From: Simon Davis
Sent: 19 March 2019 16:07
To: Planning.Responses
Subject: FW: BR/273/18/PL - The Gables Hotel, 28 Crescent Road, Bognor Regis, PO21 1QG

Subject: BR/273/18/PL - The Gables Hotel, 28 Crescent Road, Bognor Regis, PO21 1QG

In relation to the above application, please may EH make the following comments:

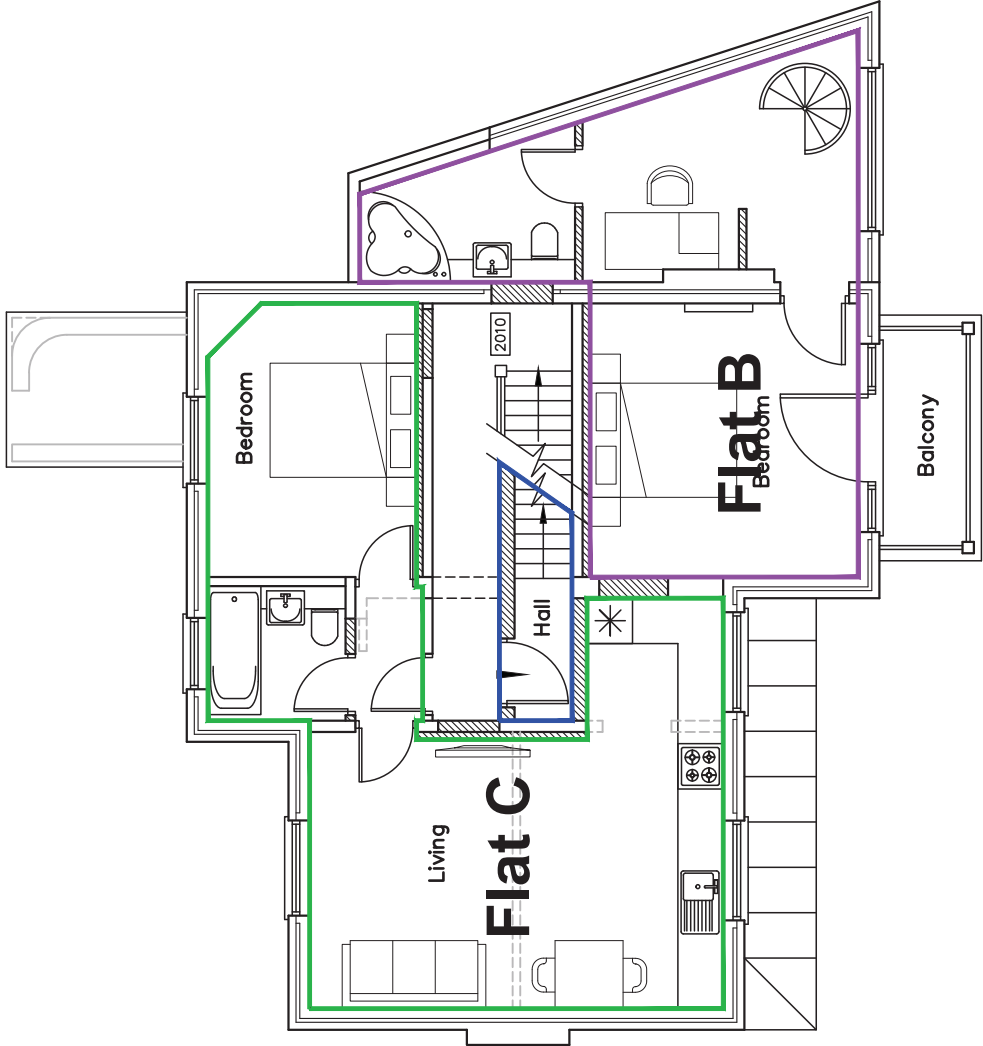
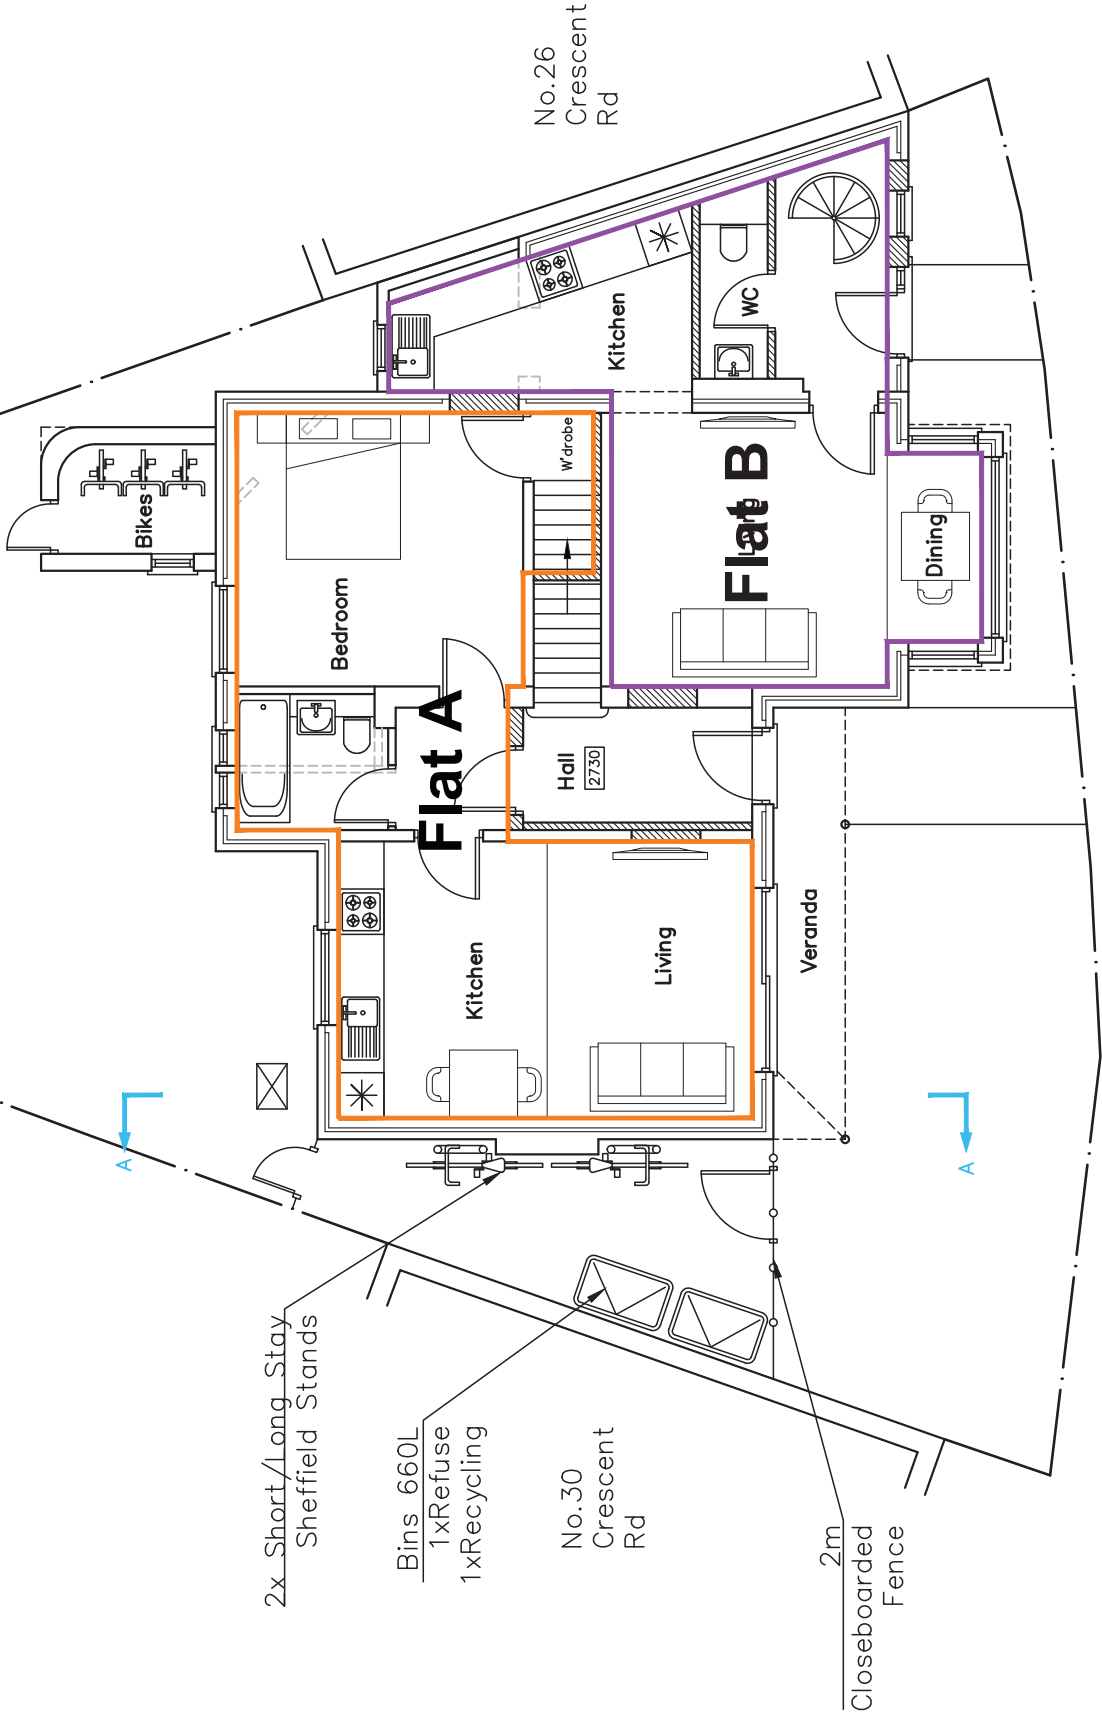
- Appropriate sound insulation should be installed between the flats, with particular attention being paid between the bedroom of Flat C and the bathroom of Flat D (although I am sure this will be addressed by Building Control).
